From: Jean Fraser
To: Veroneau, Vin
CC: Andrews, Deb; Errico, Thomas; Schmuckal, Marge
Date: 8/25/2014 3:50 PM
Subject: Signage permits at Marriott Courtyard
Attachments: Permitting process note for Vin 321 Commercial - Copy.pdf; Signage & Wayfinding Plan Marriot Portland 05-12-14.pdf

I attach the permitting note which must be considered "guidance" at this stage without a specific plan and without specific sign designs and sizes; its based on some further discussions with all reviewers including Marge Schmuckal, Zoning Administrator. It reflects ordinance text that distinguishes between signs on private land vs ROW, content, and has a specific section for "portable".

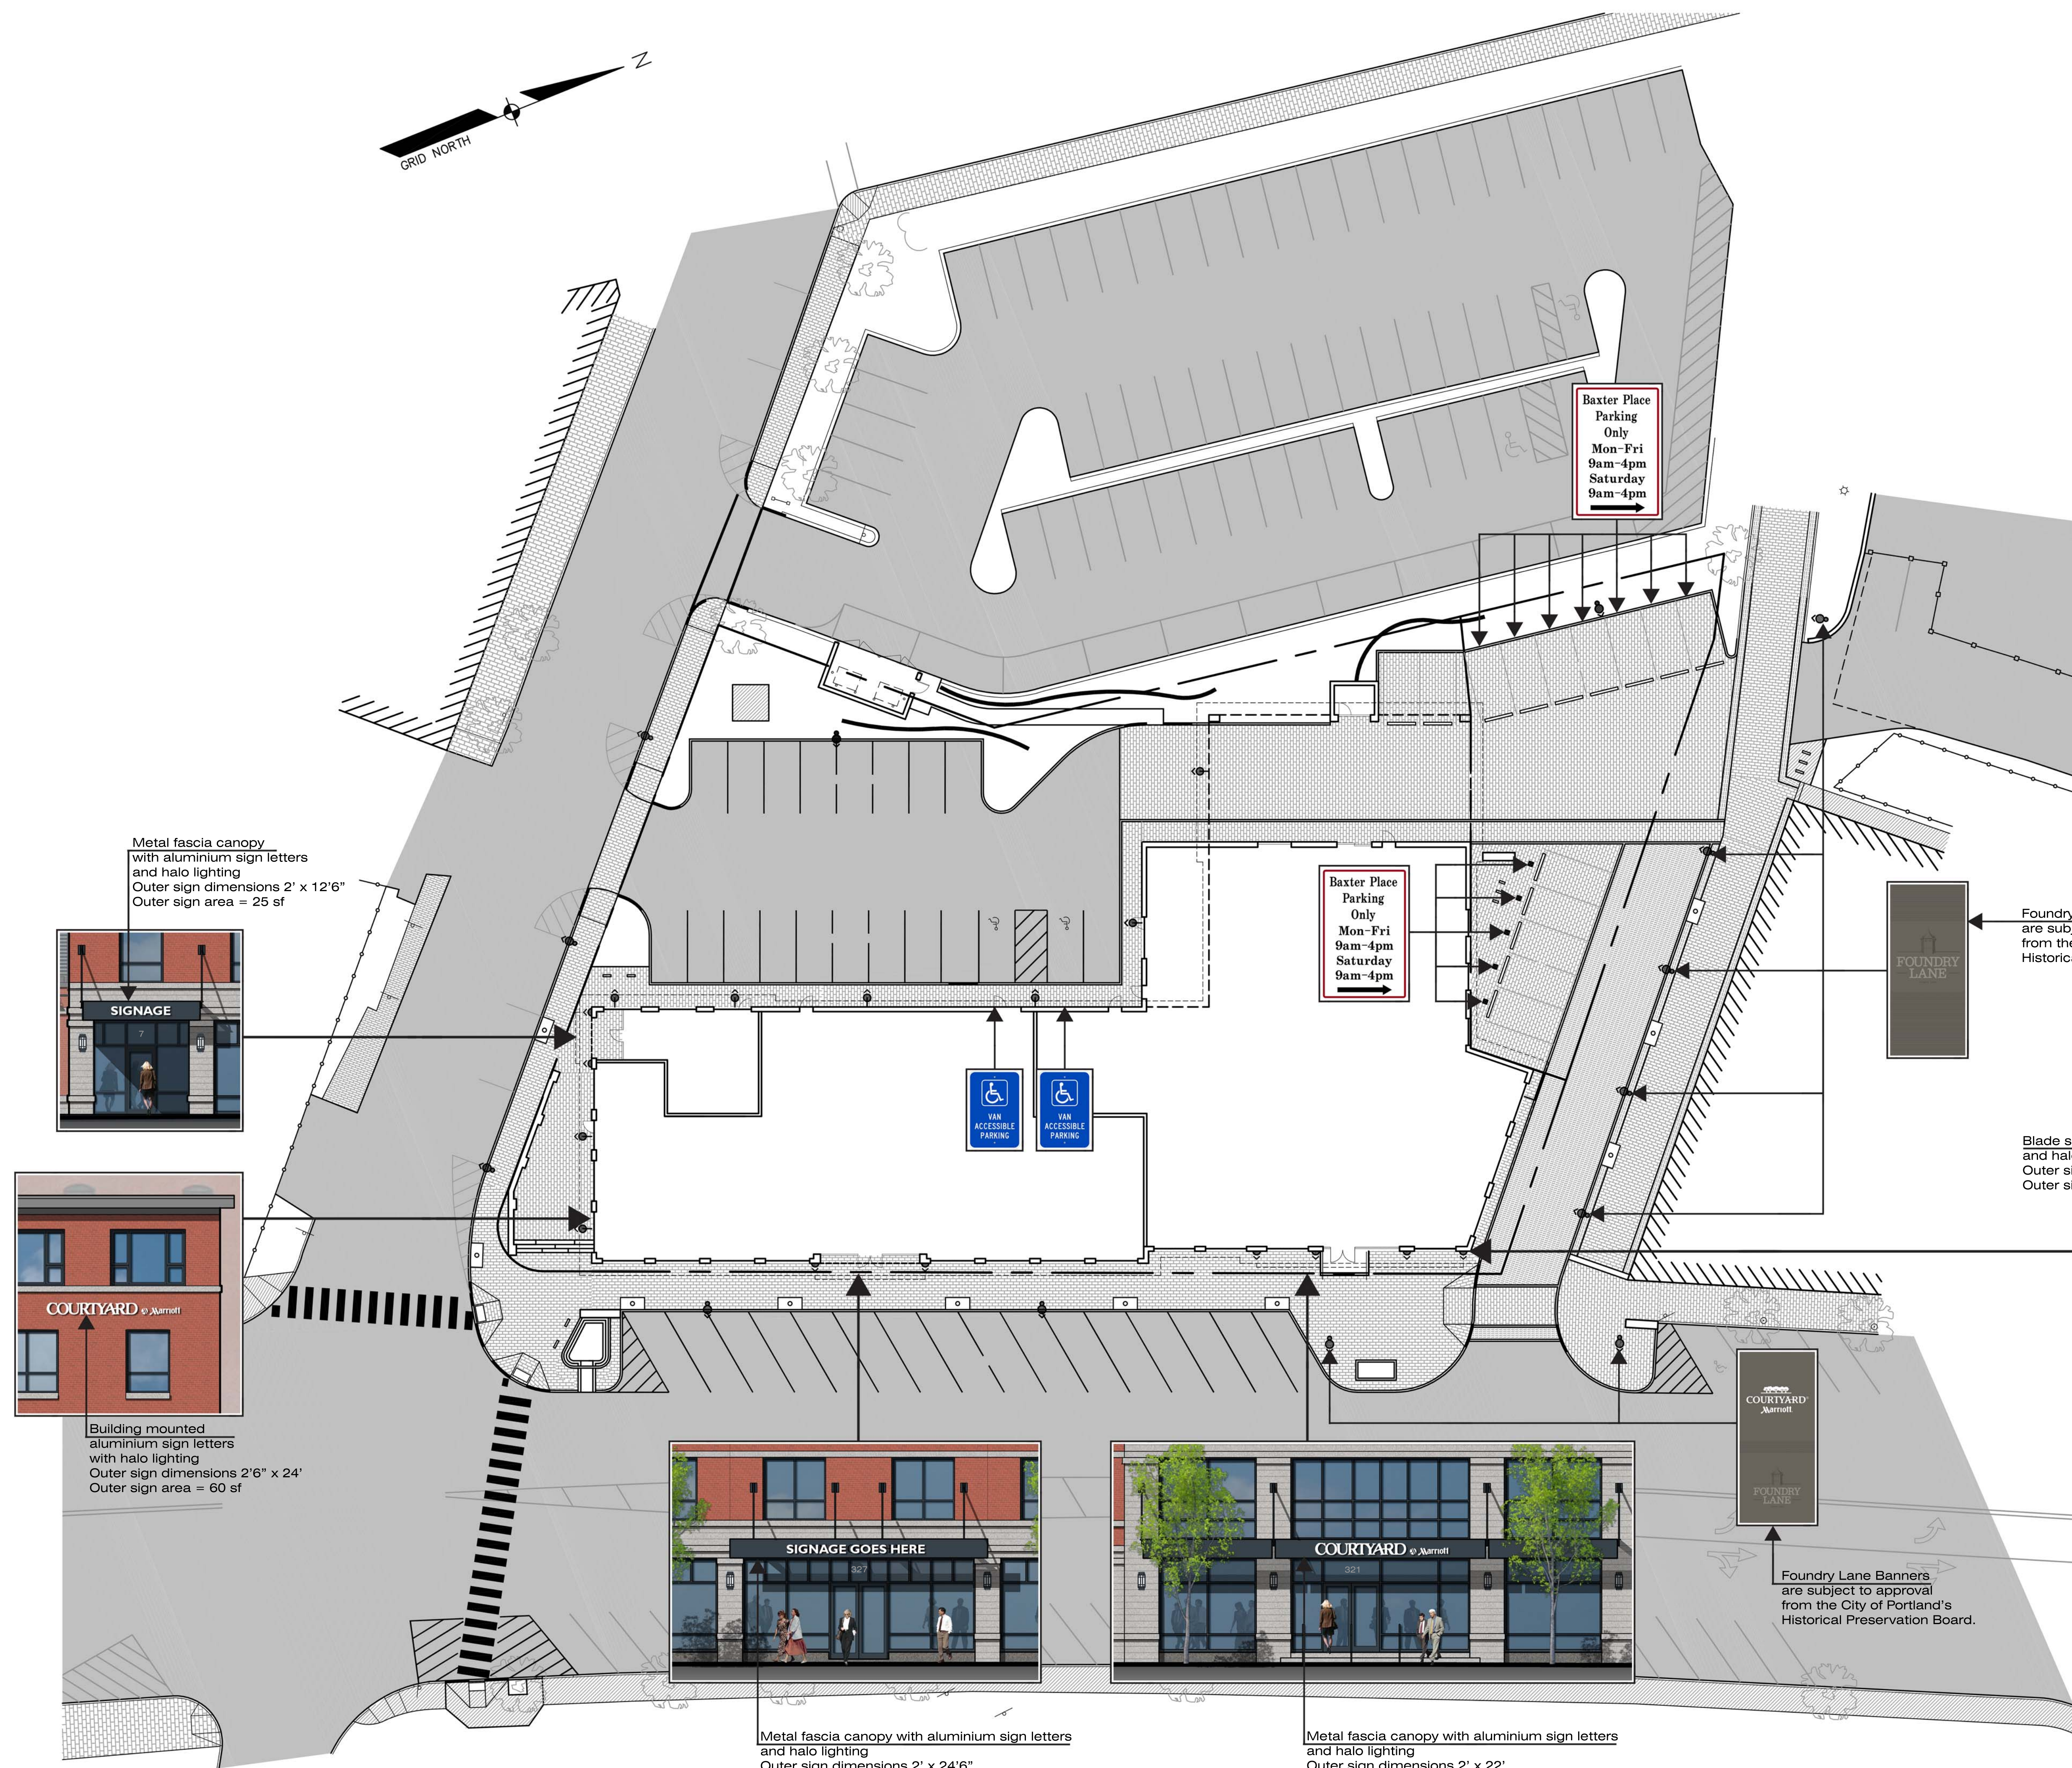
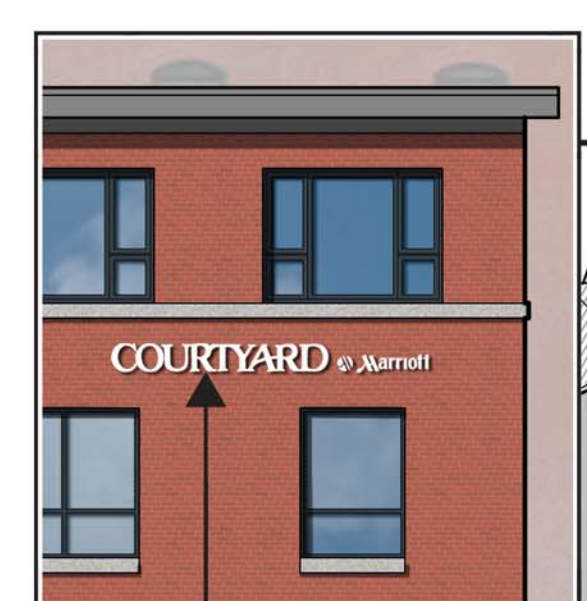
In summary, you clearly need a sign permit for the banners in Foundry Lane that have a "commercial" content eg "Marriott". The ordinance does say banners do not need a permit in this location, subject to their content not being commercial signage (and where it is commercial signage it gets added in to the total allowable for the site). All those along Foundry Lane potentially also have a directional/historic contribution and this will be a factor if they need to be reviewed under Site Plan.

The valet parking "portable" sign also definitely needs a permit and a license (details on the attached table).

Any on the light columns that say "Foundry Lane" in the ROW will probably be OK as these are in many places in Portland and these are in lieu of a street sign so are "directional" and would be considered to be put up on behalf of the City (but I will need to get DPS more involved- but first need size and design and mounting height; also Deb was going to send you some dates and you might run the banner content by her so it has historical accuracy).

I suggest that you submit a sign permit to Marge Schmuckal, Zoning Administrator (copy to me so I can liaise with Marge and keep Tom and Deb in the loop) that includes:

1. The revised plan that is similar to attached, including the "portable" sign for the valet parking and all signs in Foundry Lane and abutting ROW areas
2. A table of the sizes and designs/wording of the banners cross-referenced to the plan
3. Copy of my table as background for reviewers
